**A30 Chiverton to Carland Cross
TR010026**

**8.5 COMMENTS ON LOCAL IMPACT
REPORT**

March 2019

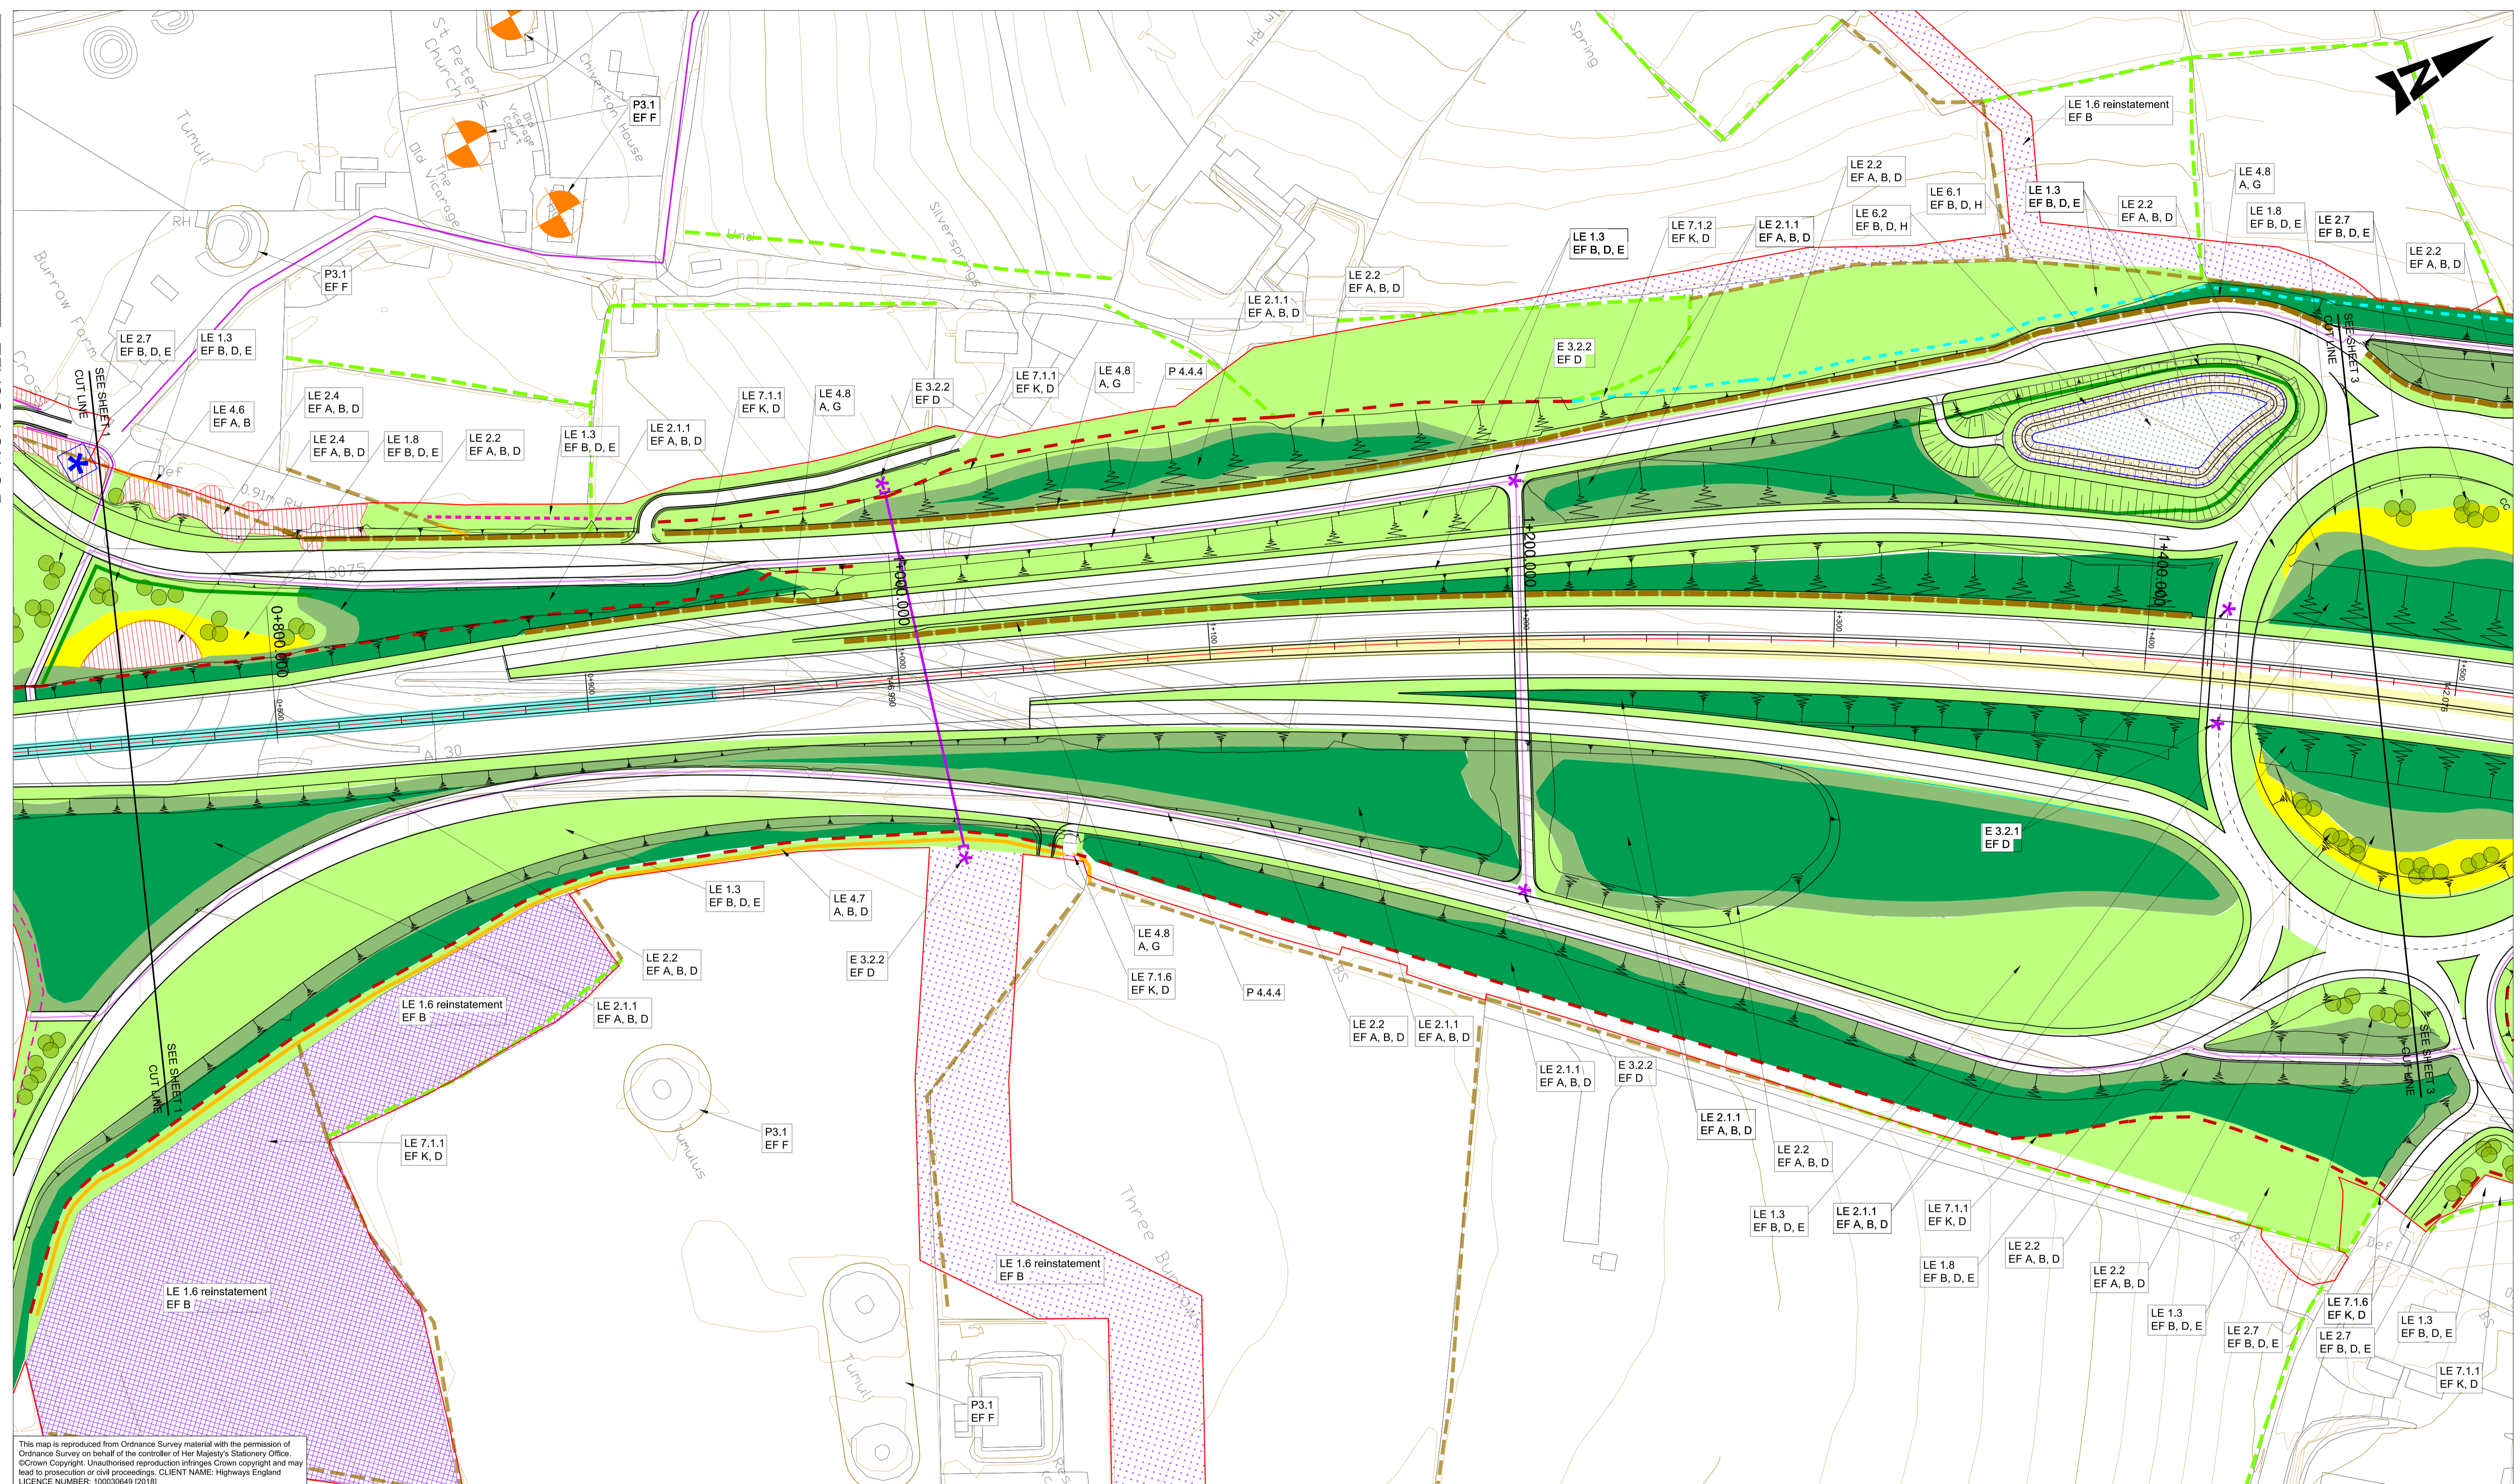
Paragraph	Text from LIR	Highways England Response
9.13	<i>VP30 – drawing Figure 7.6 Environmental Masterplan 2 of 20 shows a Cornish hedge which would be planted (LE 4.8). Therefore the 15 year winter view should not then show a flat topped hedge, as vegetation would obscure this. Figure 7.6 Environmental Masterplan 2 of 20 also shows woodland edge scrub to the slope below the hedge, so after 15 years the hedge would more than likely be completely obscured from this view</i>	Both the year 1 and the year 15 visualisations show a planted hedge with whips in year 1 and with a scrubby hedge in year 15. These are both winter views and so the vegetation is shown out of leaf and thus only filters rather than screens views.

9.16	<i>Plan 2 - the Council notes that tree planting has been removed from the areas between roads to the south east of the multi species crossing. Deciduous native planting is requested here.</i>	It is assumed this reference is to the crossing at Ch 1,200 and to the area of species rich grassland to the east and north east (north point not vertical up the page). This area could not be planted due to a forward visibility splay required for the A390 slip road.

Drawing file: TR010026 / TR010026-000247-6.3 ENVIRONMENTAL STATEMENT FIGURE 7.6 ENVIRONMENTAL MASTERPLANS, SHEET 3.pdf

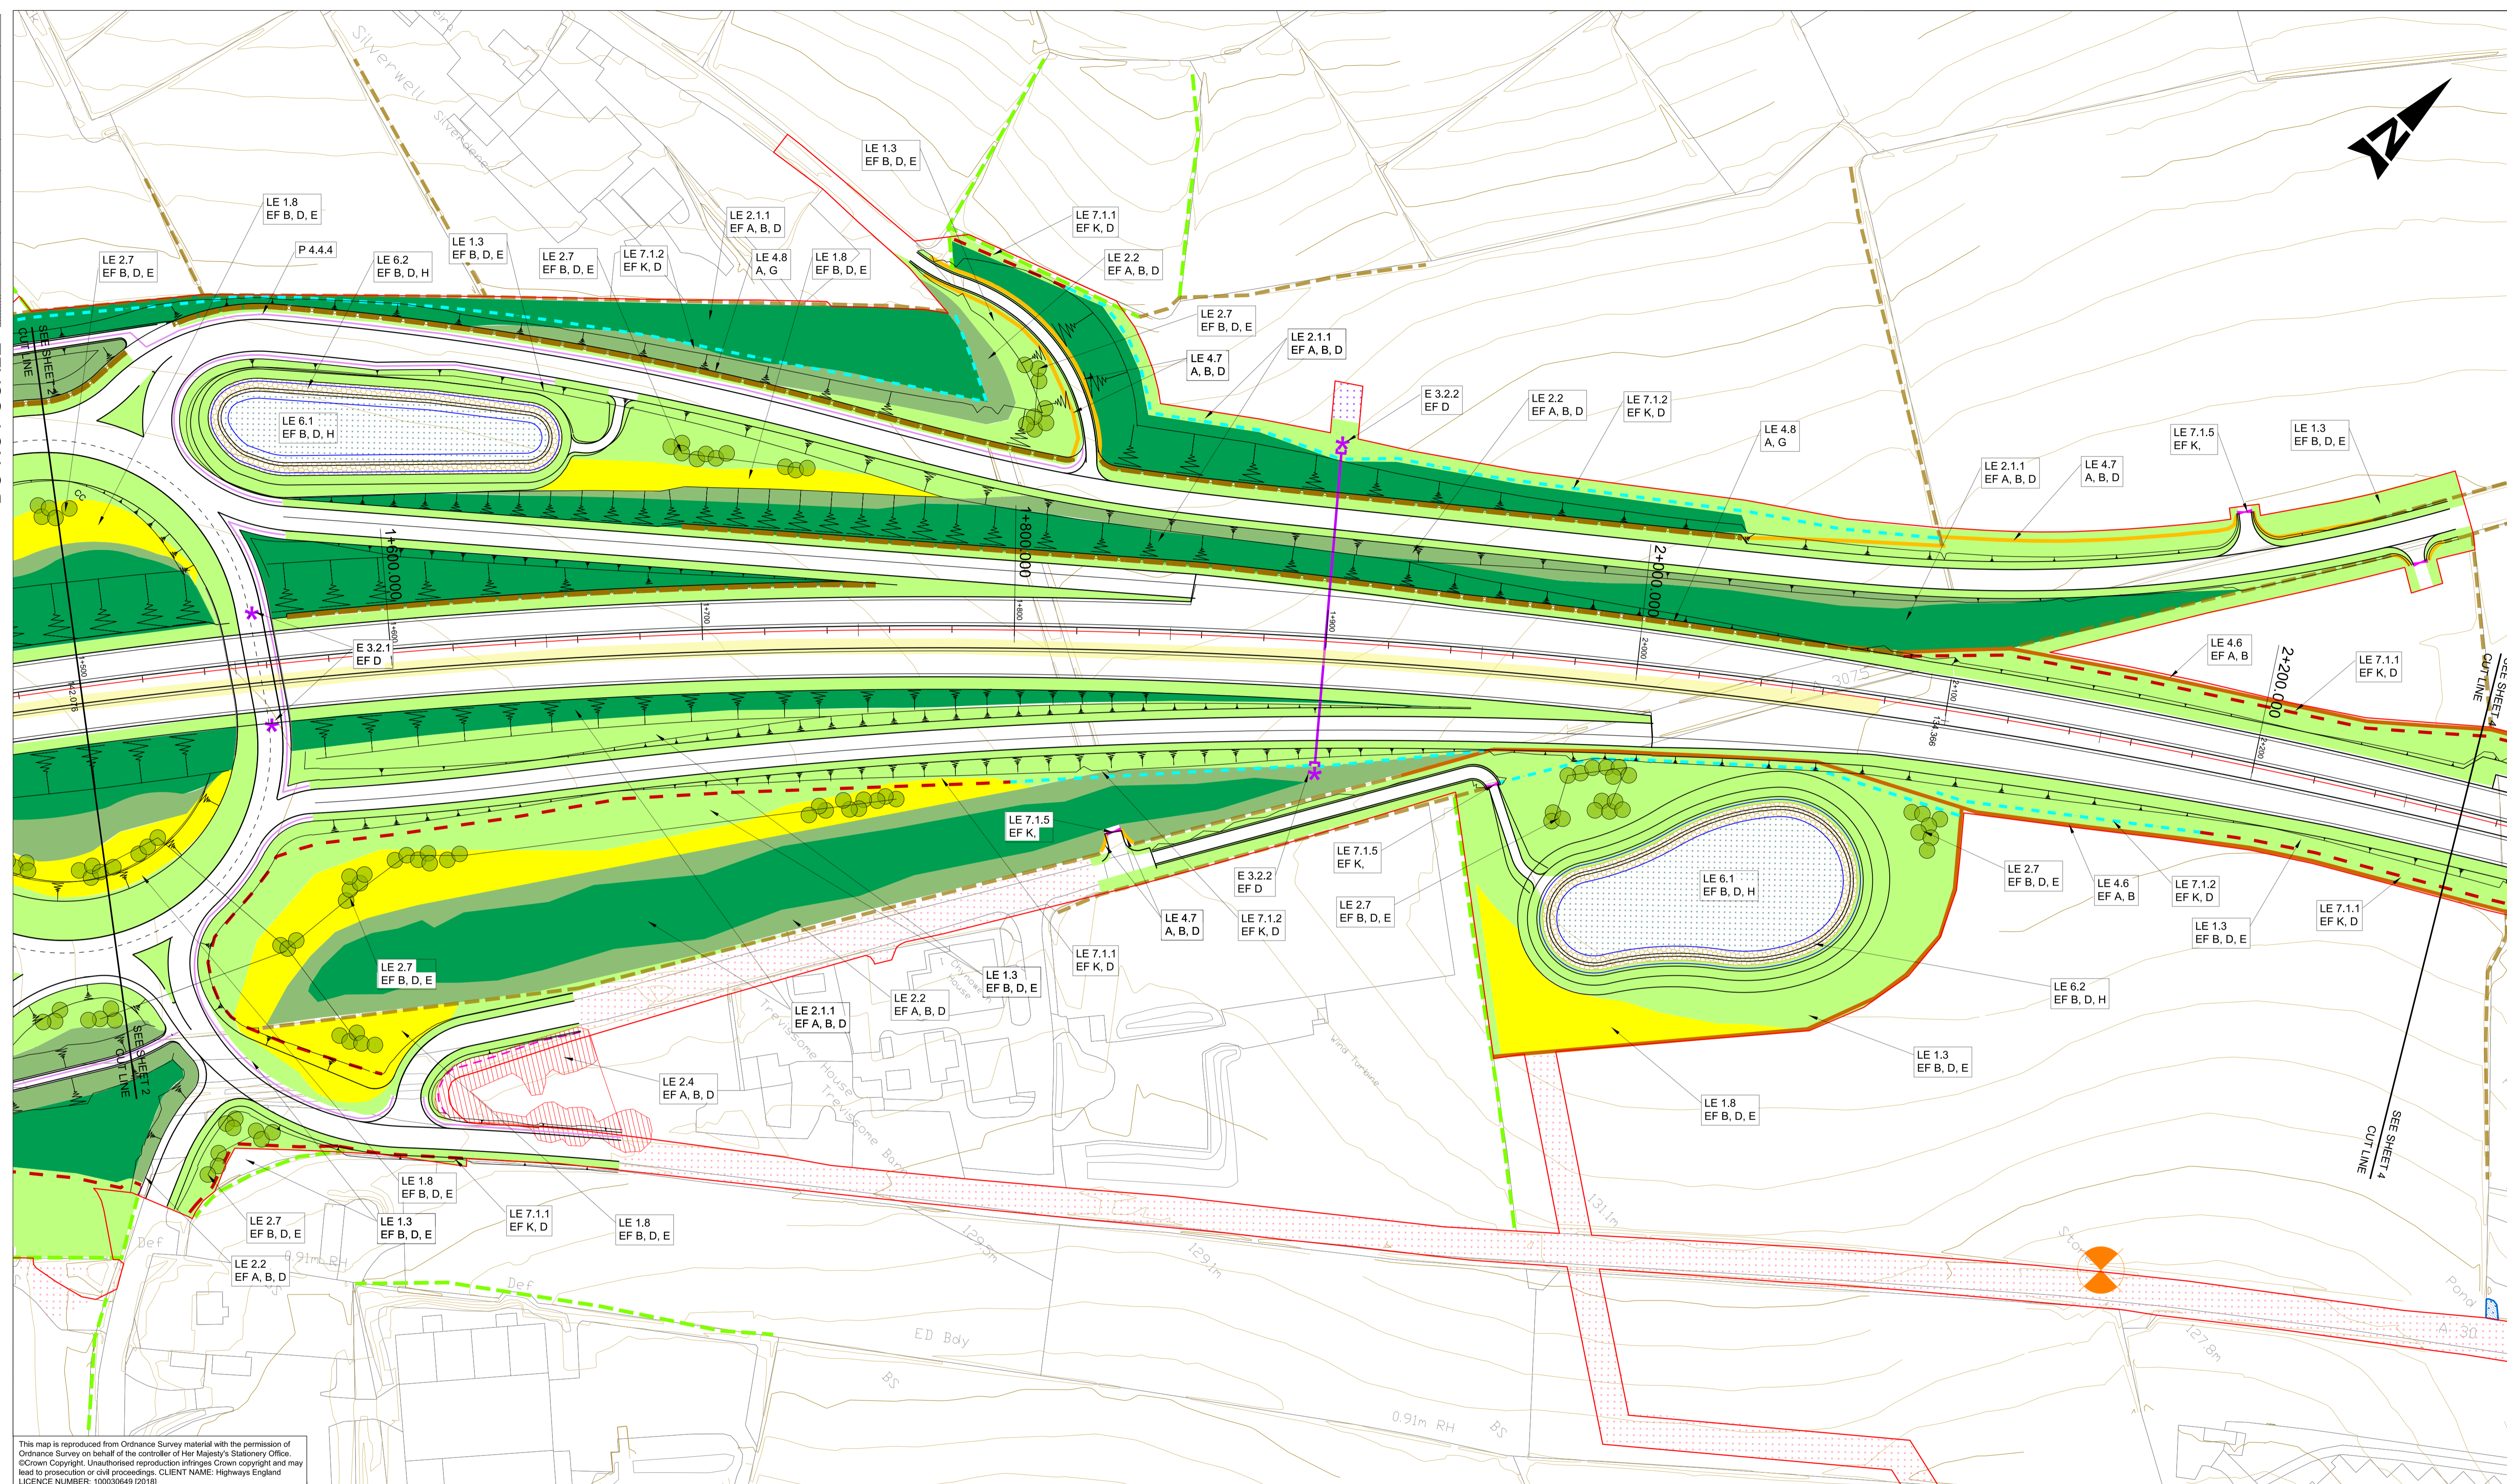
9.17	<i>Plan 3 - the Council considers that post and rail fences on the top of elevated banks are not encouraged and would give rise to a landscape and visual impact and should be replaced with a suitable alternative.</i>	Sheet 3 of 20 of the Environmental Masterplans (Document Reference 6.3) [APP-183] shows only one short length of badger fencing at the top of an embankment along the off-slip to the east of Ch 1,600. This embankment is less than 1m in height and in reality, through detailed design would be graded out gently to tie into the landscape north of Trevisson Park.
